Changes to Proposed Scheme: 2025/0414

Summary of changes & reason for removing the car park

SITE PLAN
SCALE 1:500

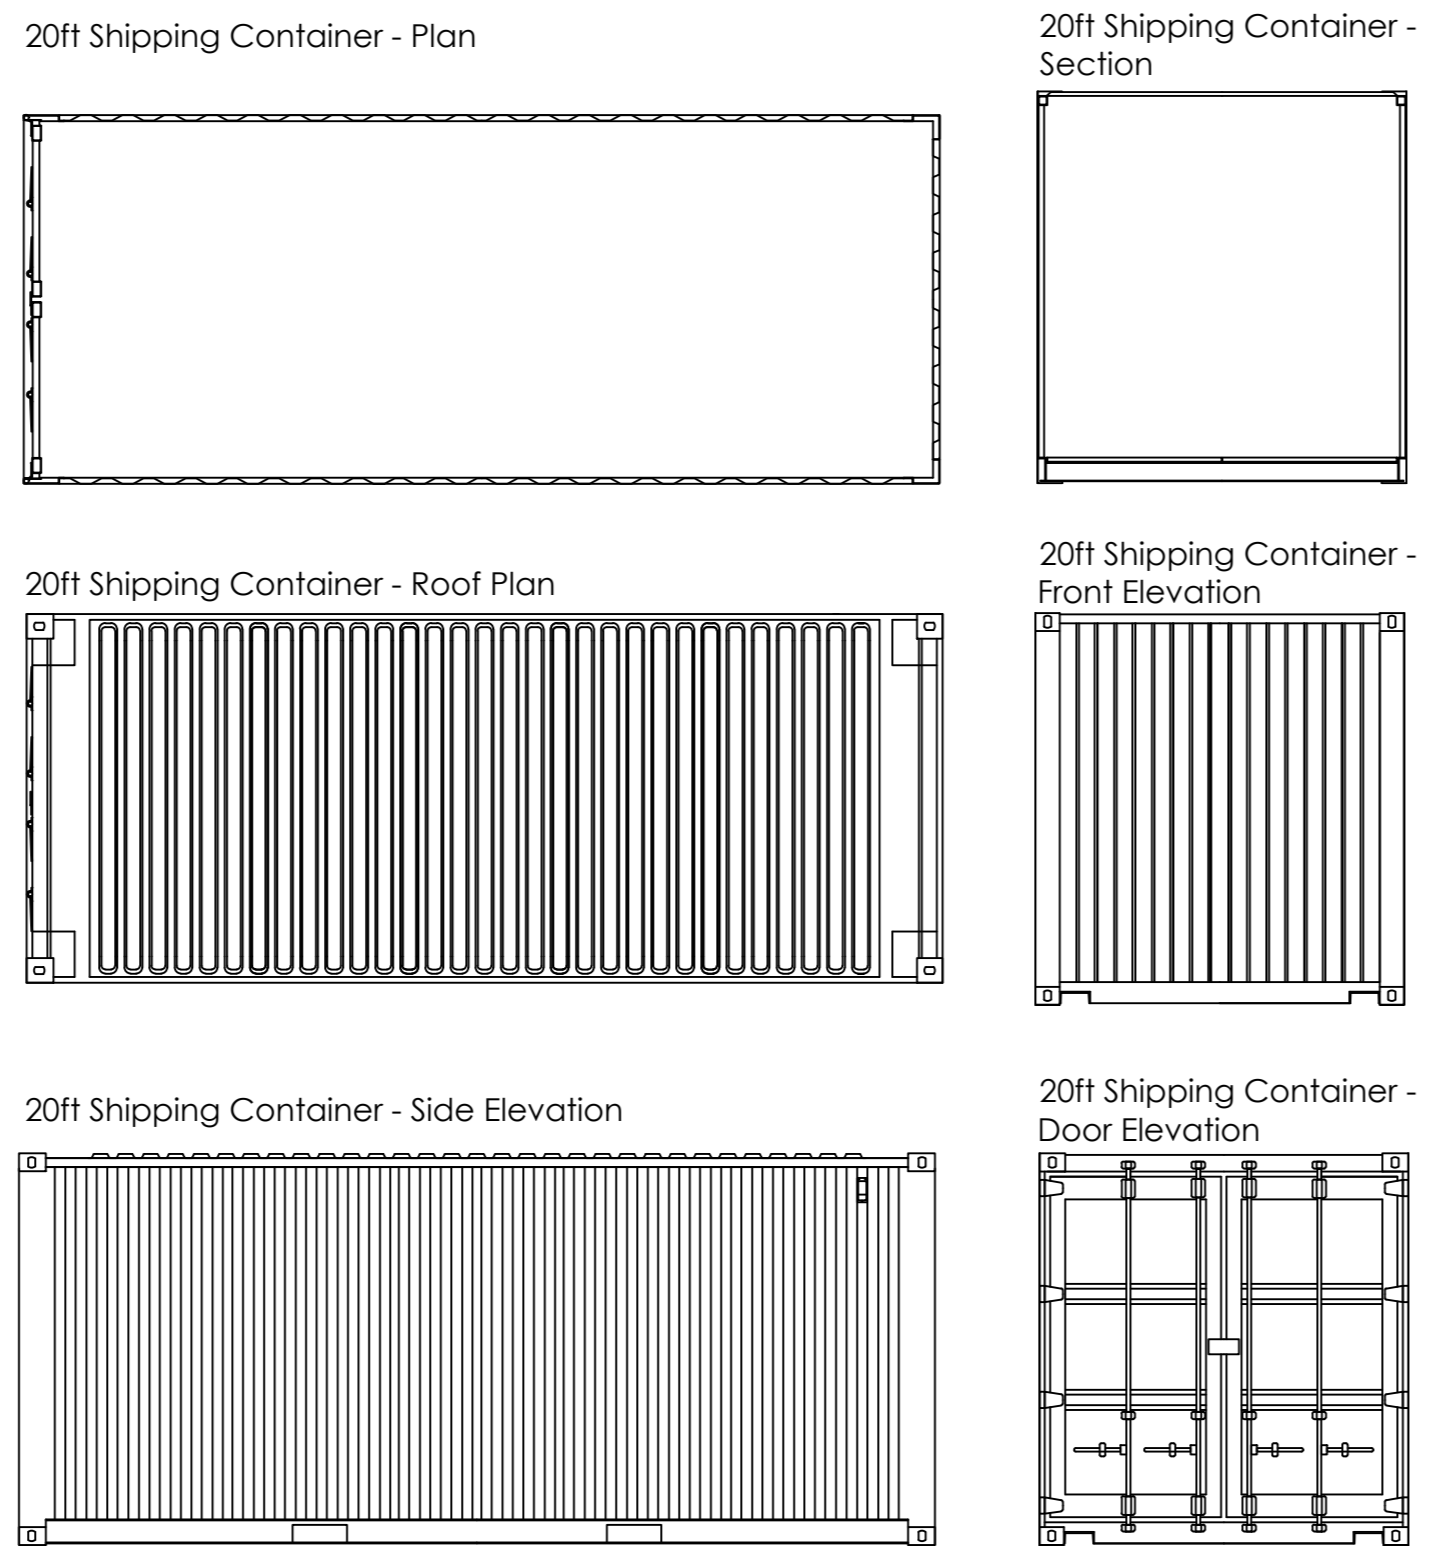
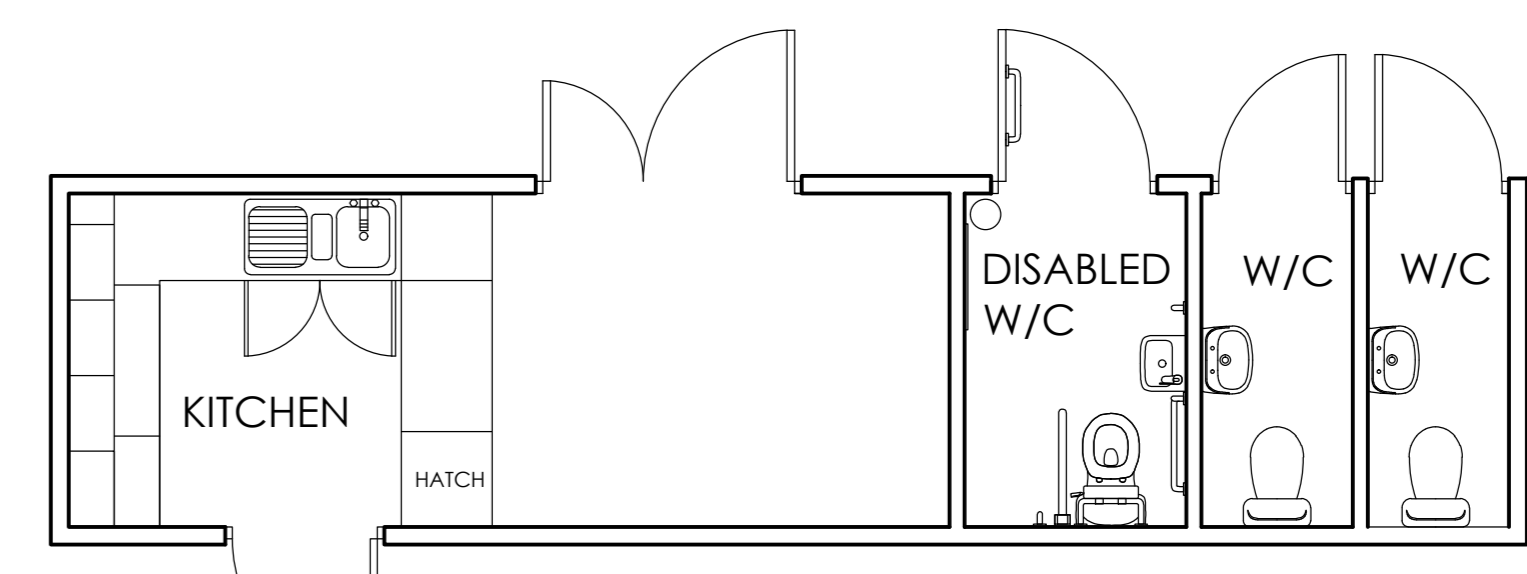
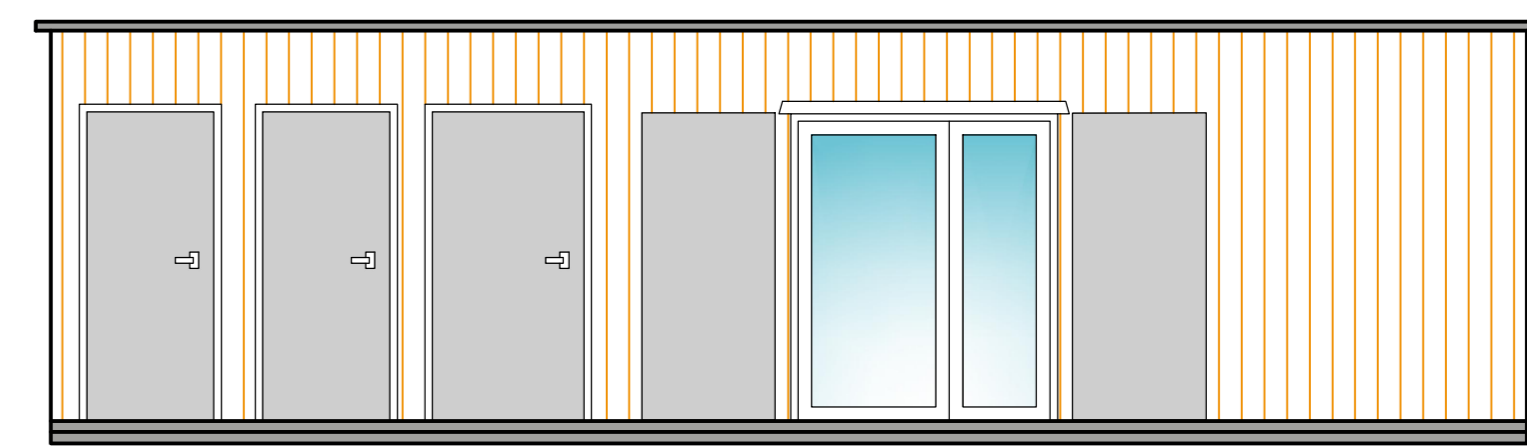
- The car park has been removed due to the biodiversity costs associated with delivering net gain for the hard-surfaced area. As a small, community-led scheme, those costs made the project unviable.
- Removing the car park avoids additional habitat loss and simplifies BNG, while also addressing the EA's concerns by limiting works to the lowest-risk areas.
